Biala Wind Farm

Landscape and Visual Impact Assessment

Independent Expert Review

December 2016

CLOUSTON associates
PRIVATE RECEPTOR
VIEWPOINT 10

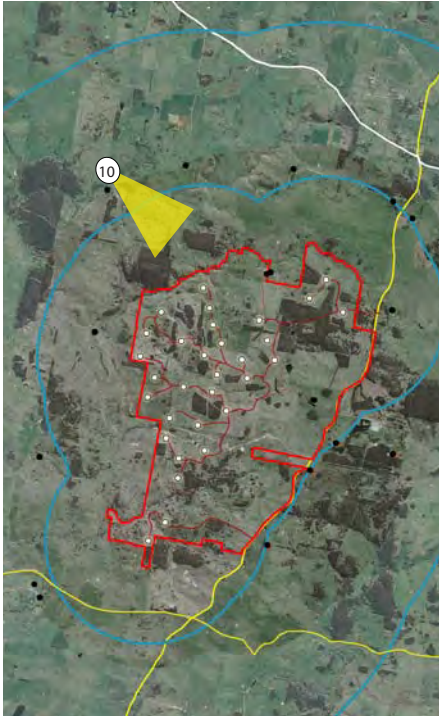
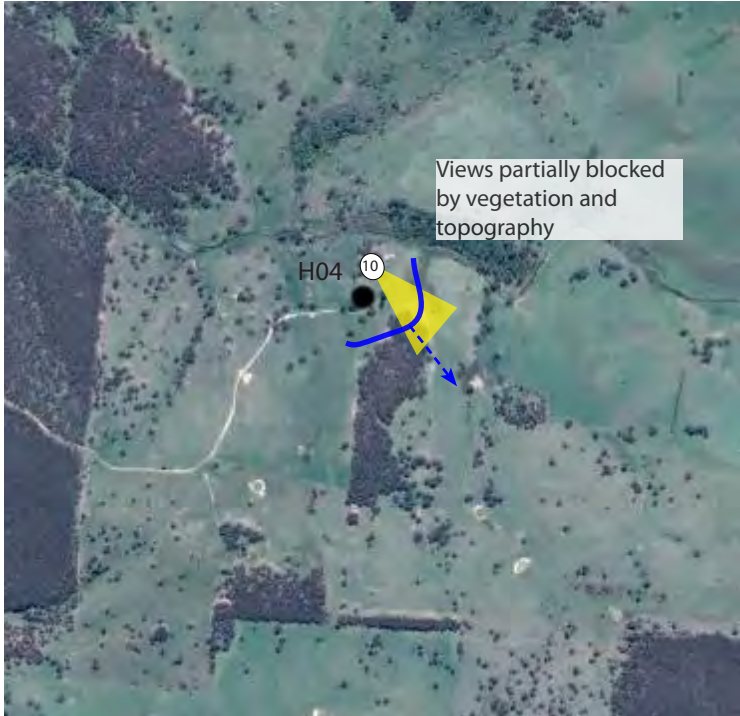
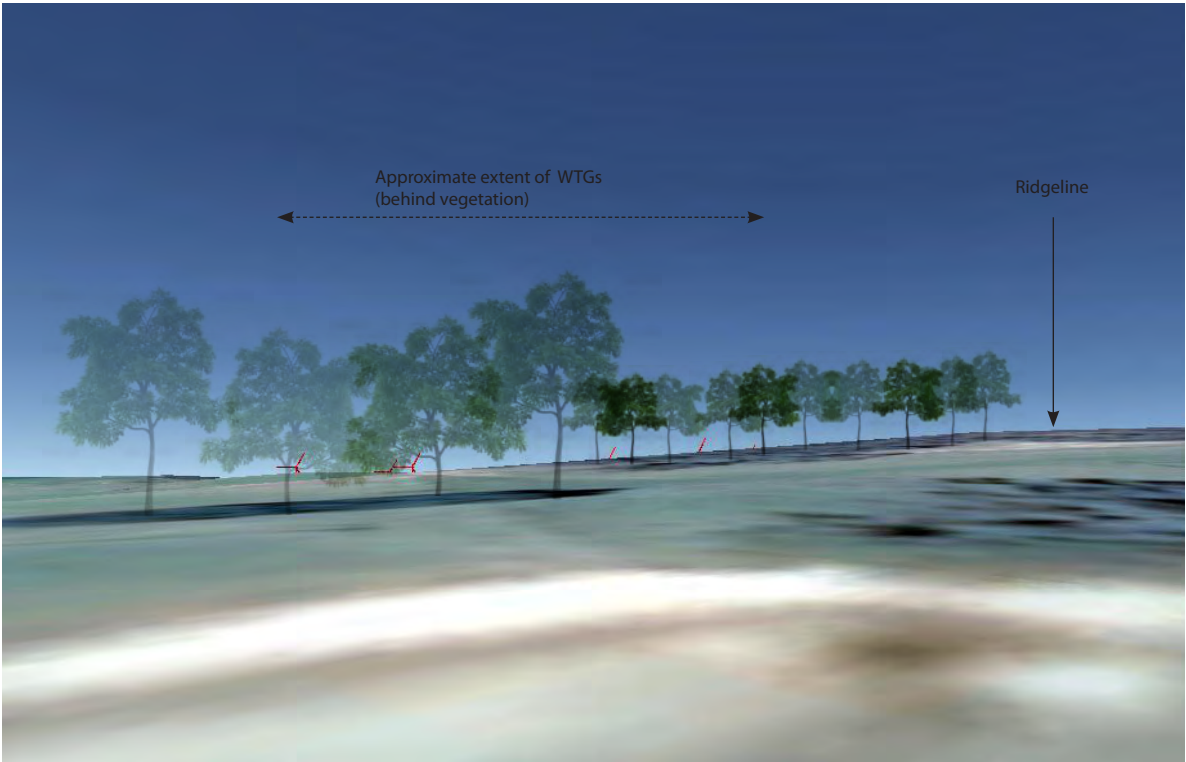
Landholder ID	Status	Clouston Associates distance from Nearest WTG (m)	Visual Impact			Discussion and recommendations
			Clouston Associates 6 June 2016	GBD Preliminary Assessment	GBD Final Assessment 15 August 2016	
H04	Non-involved	2,598	Medium to Low	Low	Nil	Opportunities to gain views toward the proposed Biala wind turbines will be limited and effectively restricted by existing topography and vegetation, including a large block of woodland between the dwelling and proposed wind turbines. GBD recommendation: No further action required.
H05	Non-involved	2,243	Medium to Low	Low	Nil	The dwelling is surrounded by tree and shrub planting which will effectively screen views toward the proposed Biala wind turbines. GBD recommendation: No further action required.
H06	Non-involved	2,004	Medium	Low	Medium	Wind turbines within the operational Gullen Range Wind Farm are not visible from the H06 residence or residential curtilage. The closest Gullen Range wind turbines, within the north portion of the Gullen Range wind farm (around 4 kilometres east to north east of the residence), are screened by gently rising and undulating landform with mature tree cover south of Grabben Gullen village. Views toward the Biala wind turbines from rooms within the dwelling will be screened by a single row of conifers forming a hedge along the

Landholder ID	Status	Clouston Associates distance from Nearest WTG (m)	Visual Impact			Discussion and recommendations
			Clouston Associates 6 June 2016	GBD Preliminary Assessment	GBD Final Assessment 15 August 2016	
						southern boundary of the dwelling curtilage. Views toward the Biala wind turbines from the dwelling curtilage, including areas of the garden to the north, west and south of the dwelling, will also be screened by tree planting alongside the dwelling curtilage. The Biala wind turbines will be visible from a relatively small area of the dwelling curtilage (to the south and south east of the dwelling). Wind turbine visibility will be more distinct and direct from the driveway between the conifer hedge and tree planting to the east of the dwelling. Views will extend toward the majority of wind turbines from vehicles travelling to and from the dwelling, as well as for people working or relaxing within this portion of the property. Mitigation measures: Whilst views from within the dwelling toward the Biala wind turbines are screened by a conifer hedge, mitigation measures should be considered to supplement existing hedgerow planting and provide longer term screening potential. Subject to discussions with the landowner, additional planting to extend screening from areas of the garden to the south and south east of the dwelling should be

Landholder ID	Status	Clouston Associates distance from Nearest WTG (m)	Visual Impact			Discussion and recommendations
			Clouston Associates 6 June 2016	GBD Preliminary Assessment	GBD Final Assessment 15 August 2016	
						considered. GBD recommendation: The Proponent should be required to consult with, and offer mitigation, through landscape treatments to the landholder/s of residential dwelling H06. Mitigation should be considered with specific regard to the potential extension and/or supplement of existing conifer planting to the south of the dwelling and along the residential driveway.
H07	Non-involved	2,062	Medium	Medium	Medium	Wind turbines within the operational Gullen Range Wind Farm are visible to the north east and east of the H07 dwelling, the immediate dwelling curtilage, as well as general working areas surrounding farm buildings beyond the dwelling. Views toward the Gullen Range wind turbines from H07 include towers and full rotors as well as partial views to rotors where partially screened by clumps and scattered groups of tree cover to the north and north east of the residence. The more distinct and directly visible Gullen Range wind turbines are located within a portion of the northern sector of the Gullen Range
